PLANNING BOARD REPORT PORTLAND, MAINE

MMC Congress Street Hospital Building
22 Bramhall Street
Level III Site Plan
Project #000331-2018
53-D-7
Maine Medical Center, Applicant

Submitted to: Portland Planning Board Public Hearing Date: December 17, 2018	Prepared by: Nell Donaldson, Senior Planner Date: December 14, 2018
---	--

Phase 2B  
Close sidewalk  
Remove Traffic Lights  
Extend curbing  
Update Utilities  
Install new sidewalk

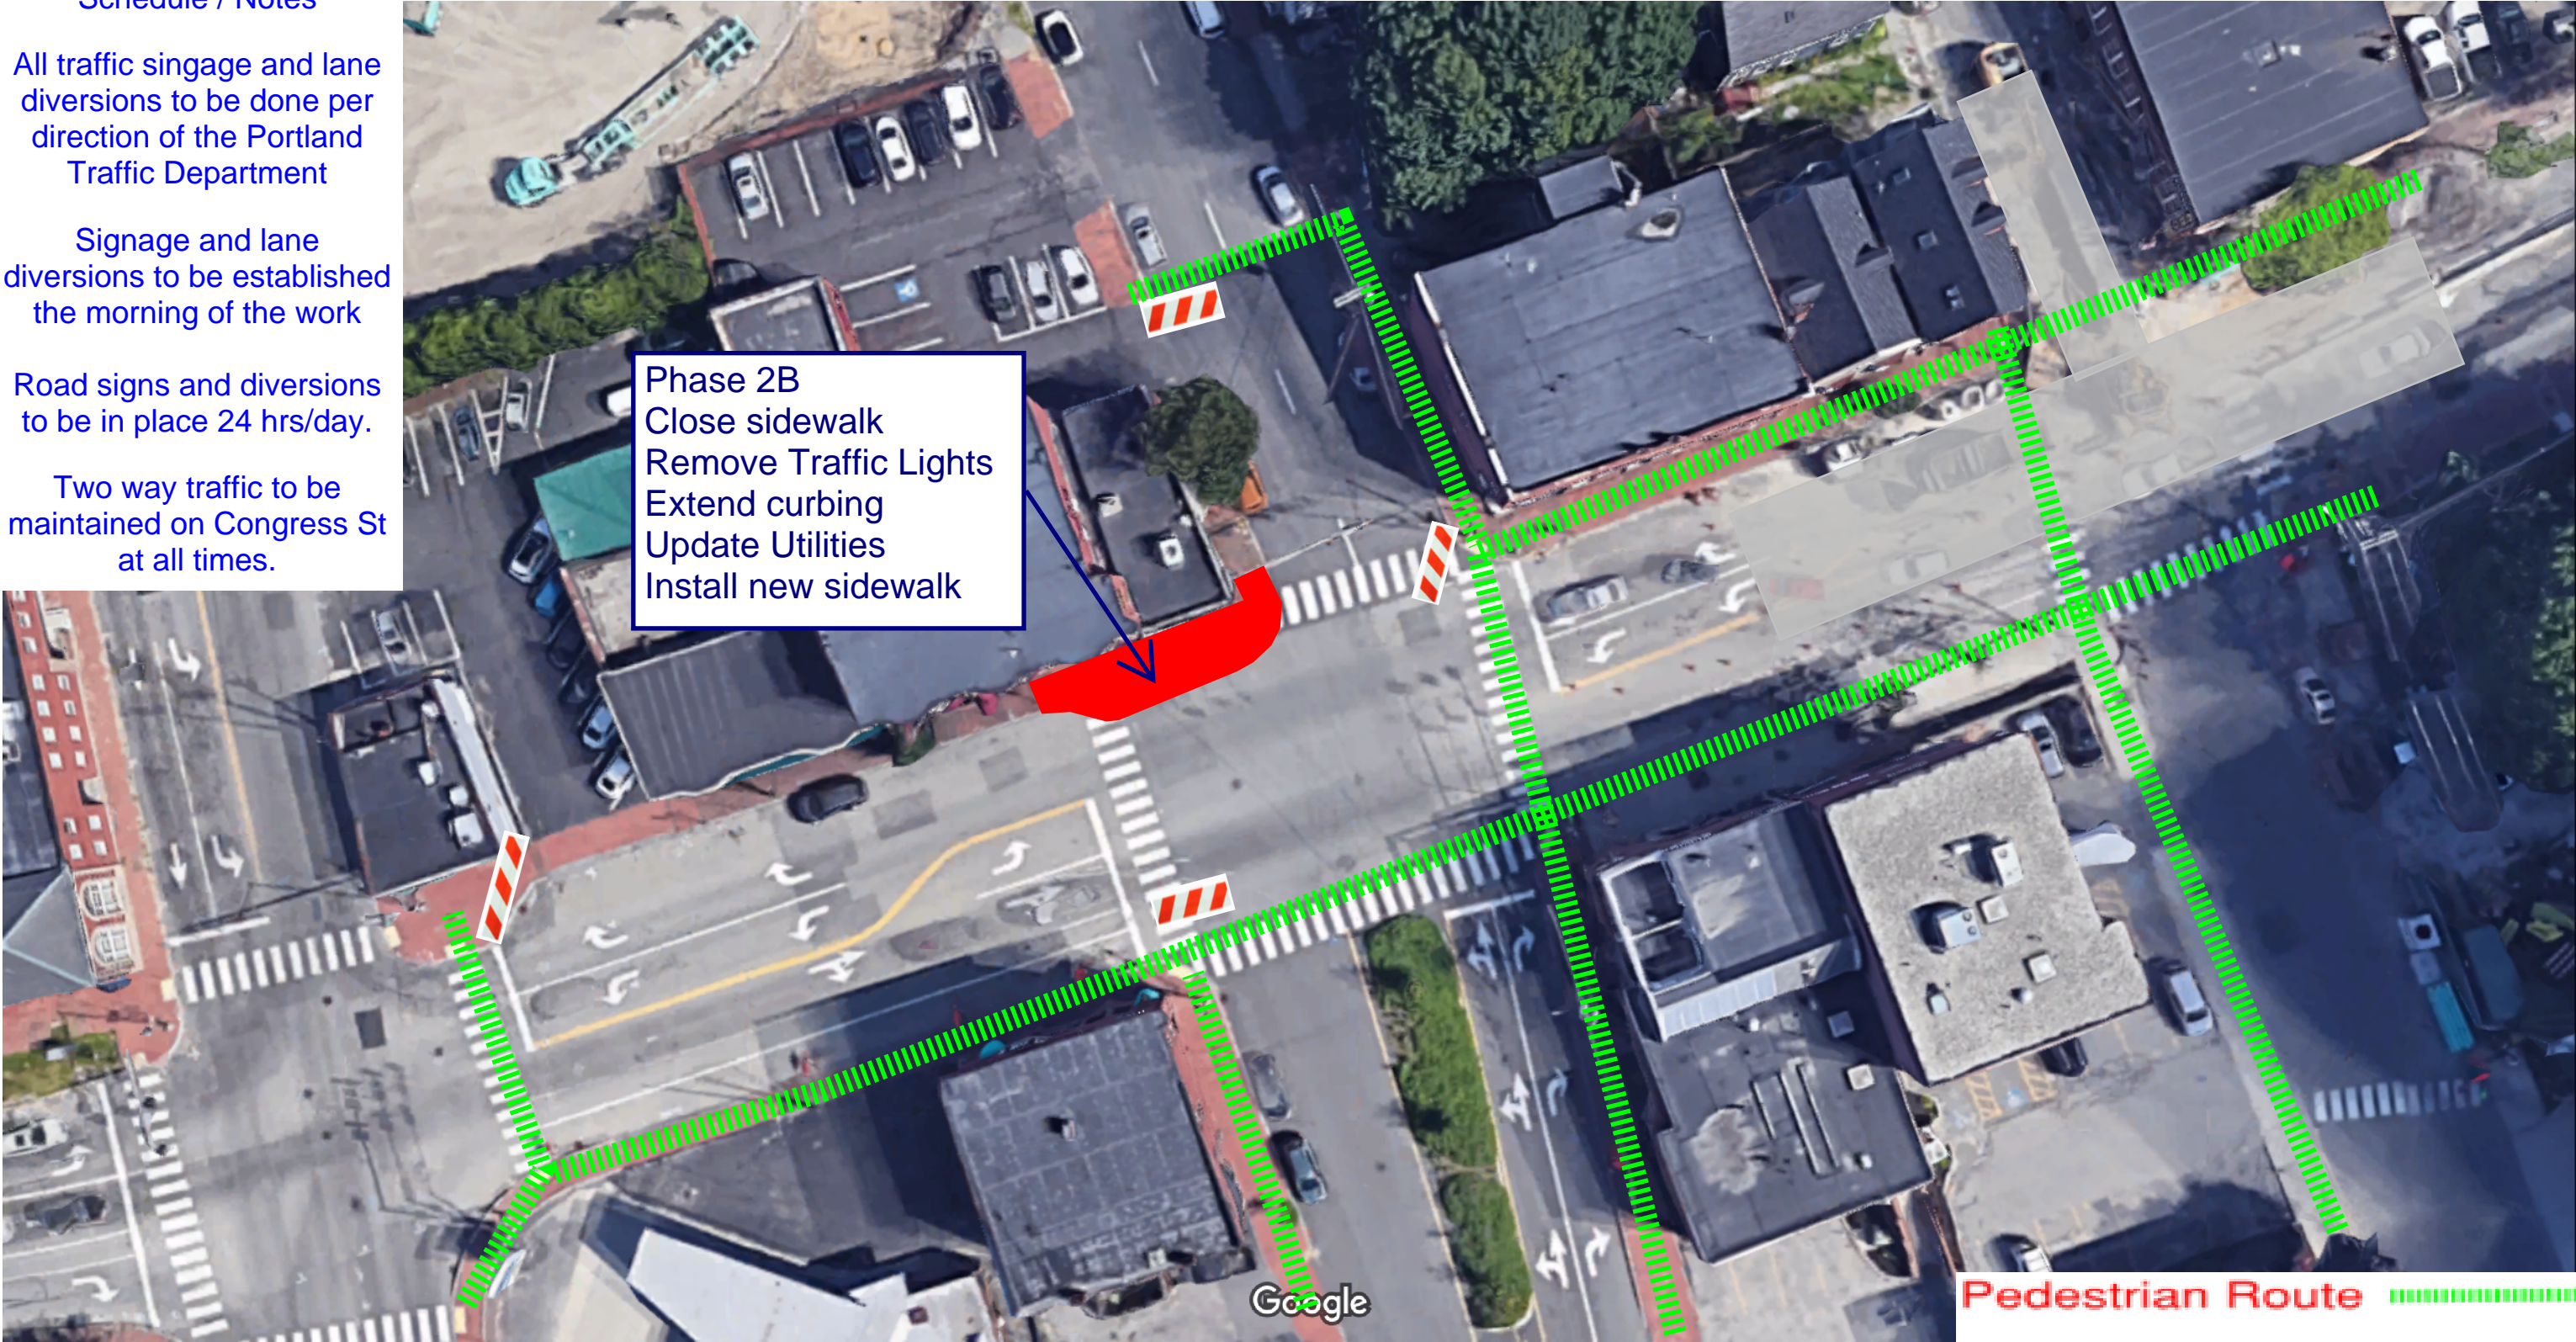
It is recommended that further discussion on the duration of the Congress Street sidewalk closures be included.

Supplemental pedestrian safety devices will be required during the sidewalk closure time period (to safely cross pedestrians for the sidewalk detour).

All sidewalk detours shall be ADA compliant.

Changes to the lane configuration on Congress Street west of Gilman Street is likely and may need to be included in the plan.

A significant amount of construction activity will be required for utility and street construction work and specific plans shall be development for review and approval.

Preliminary Sign Location Plan

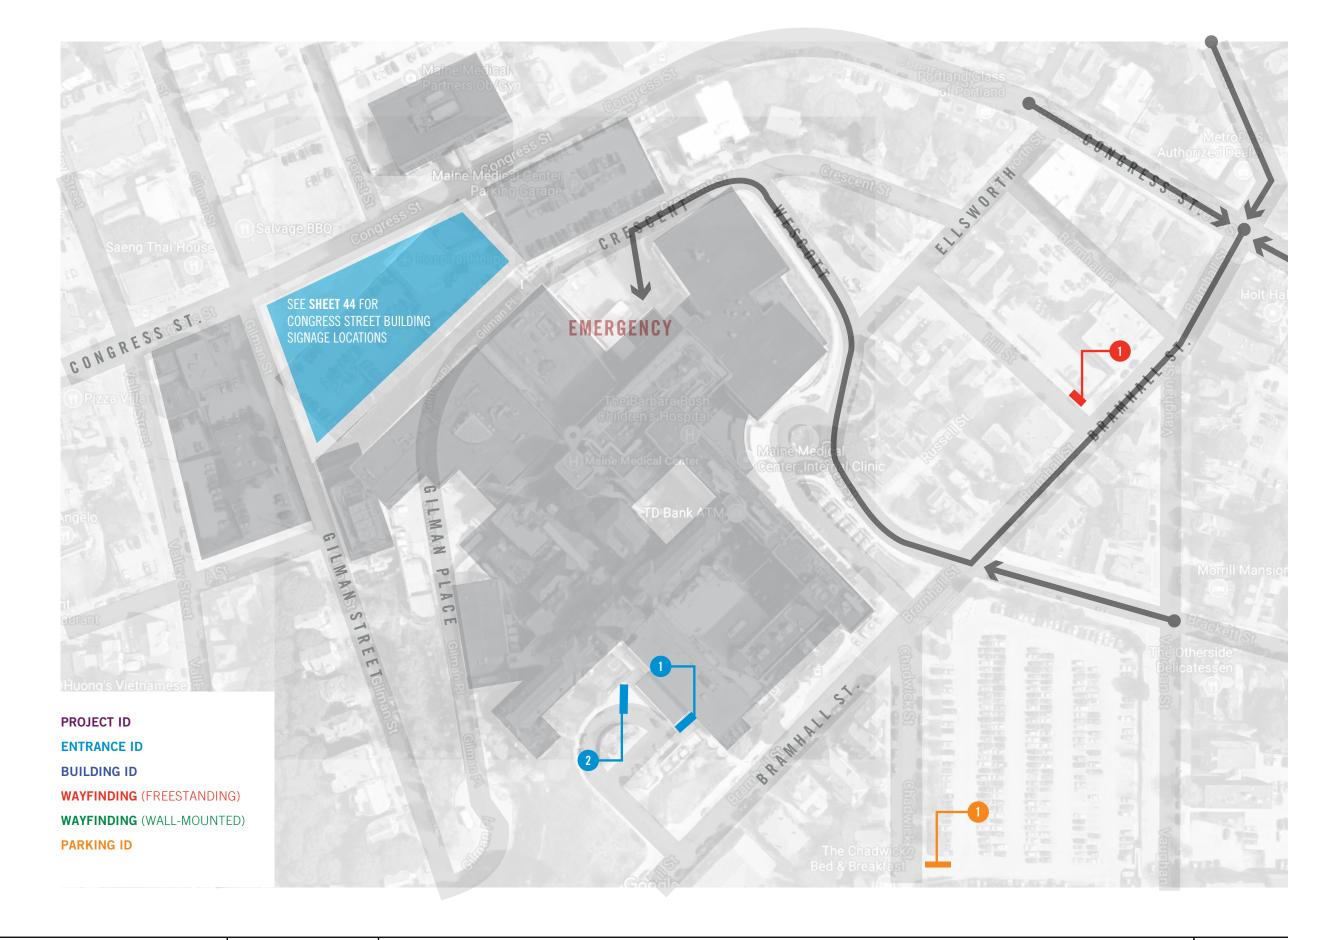
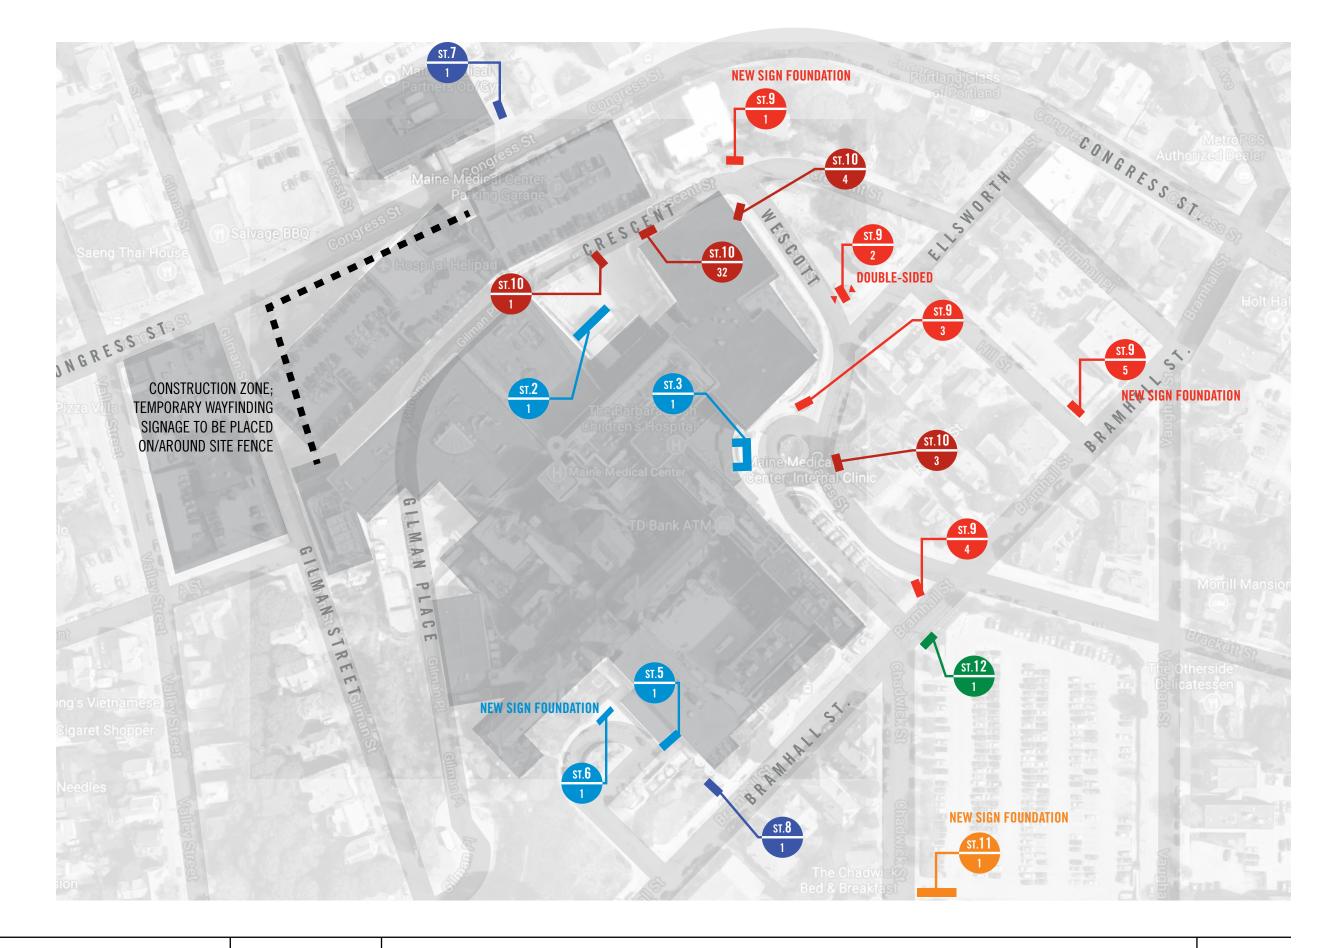
Correct any errors regarding sign placement or type

Remove the "Susie's Story" graphic and text components from the back of signs

Clarify shape and type of sign at the corner of Congress Street and Gilman Street

Remove street signs as shown on pages 30 and 31. Revisions to the blue H signage will be coordinated between staff and the applicant separate from this campus sign plan.

Provide documentation showing that signs proposed on Bramhall Street and Wescott Street are to be placed on MMC-owned property.
